Consultation Response from KC,

Lead Local Flood Authority

2022/91477 Land off Lindley Moor Road, Lindley, Huddersfield, HD3 3SX

Hybrid Planning Application for the erection of an industrial unit for E(g)/B2 /B8 use with associated access, parking, groundworks and landscaping in conjunction with an outline application for mixed use development use class E(a), E(b), E(g), B2 and B8

Proposed Site Plan Showing Section Lines  
1 : 500

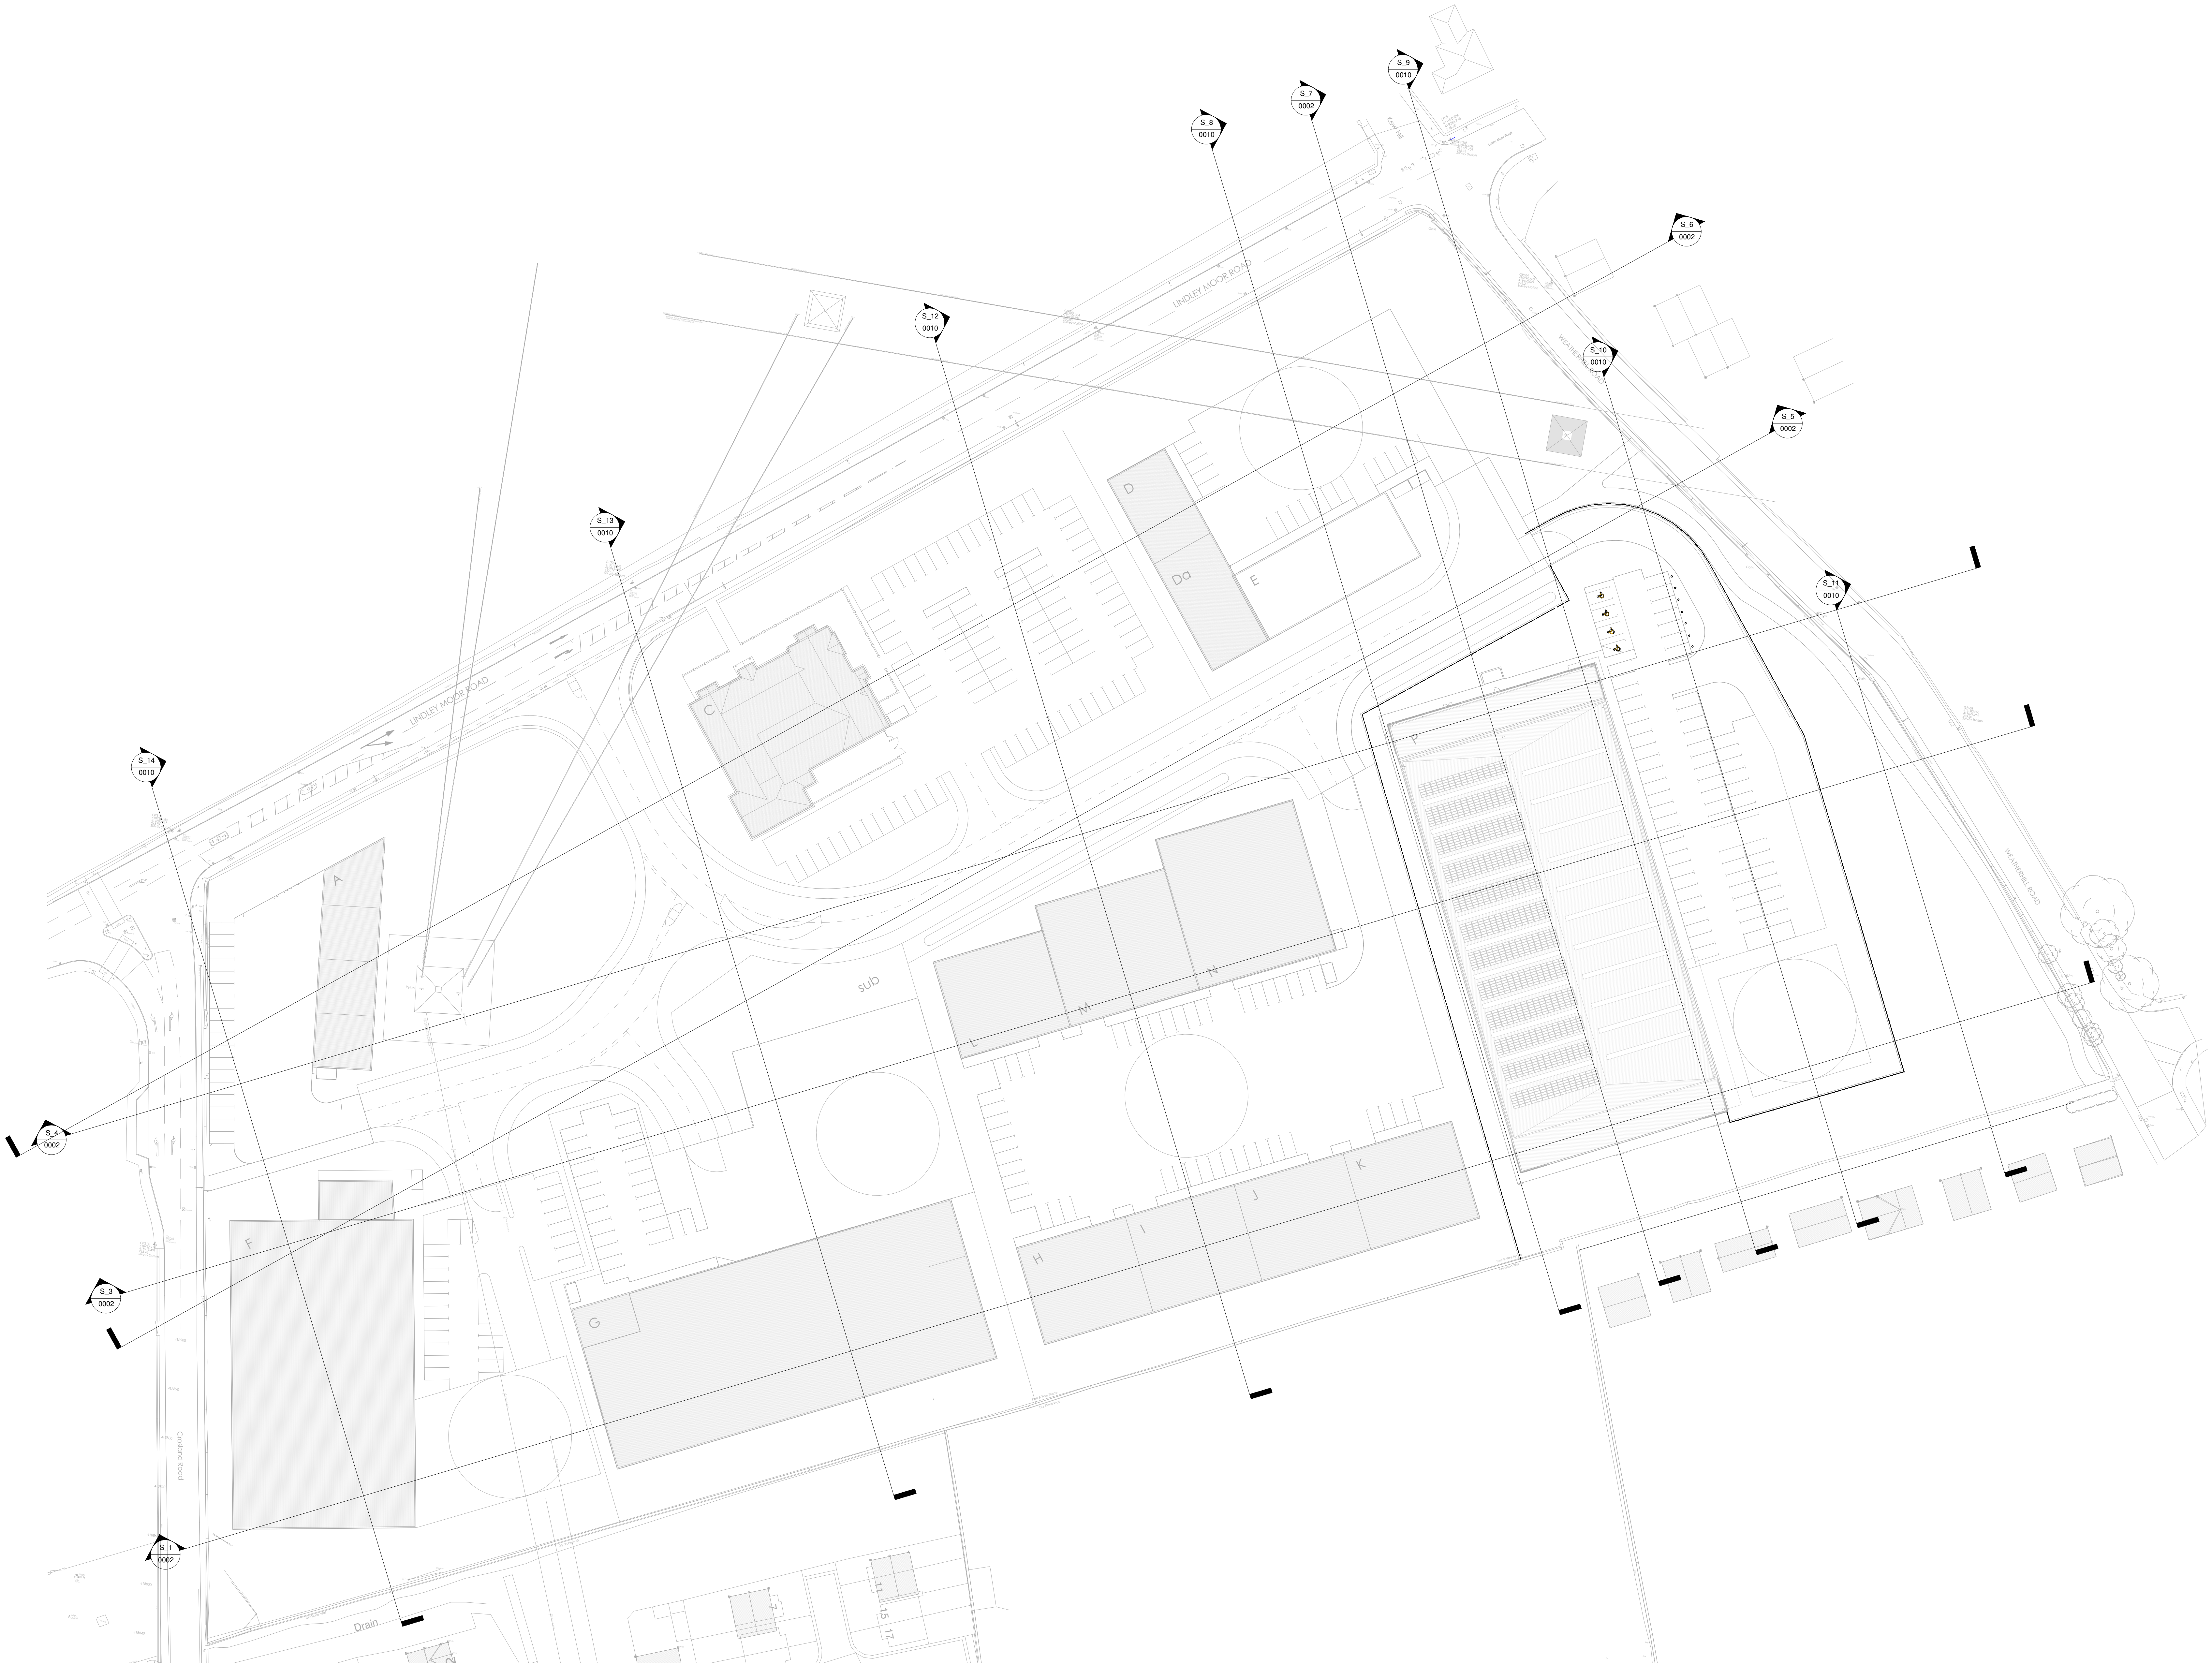
The use of a boundary wall sloping toward Weatherhill Road is shown to protect properties should a blockage scenario or exceedance event occur. Again, detailed design and a verification that safe flood routing remains will be conditioned.

The development shall not commence until an assessment of the effects of 1 in 100 year storm events, with an additional allowance for climate change, blockage scenarios and exceedance events on drainage infrastructure and surface water run-off pre and post development between the development and the surrounding area, in both directions, has been submitted to and approved in writing by the Local Planning Authority. No part of the development shall be brought into use until the works comprising the approved scheme have been completed and such approved scheme shall be retained thereafter.
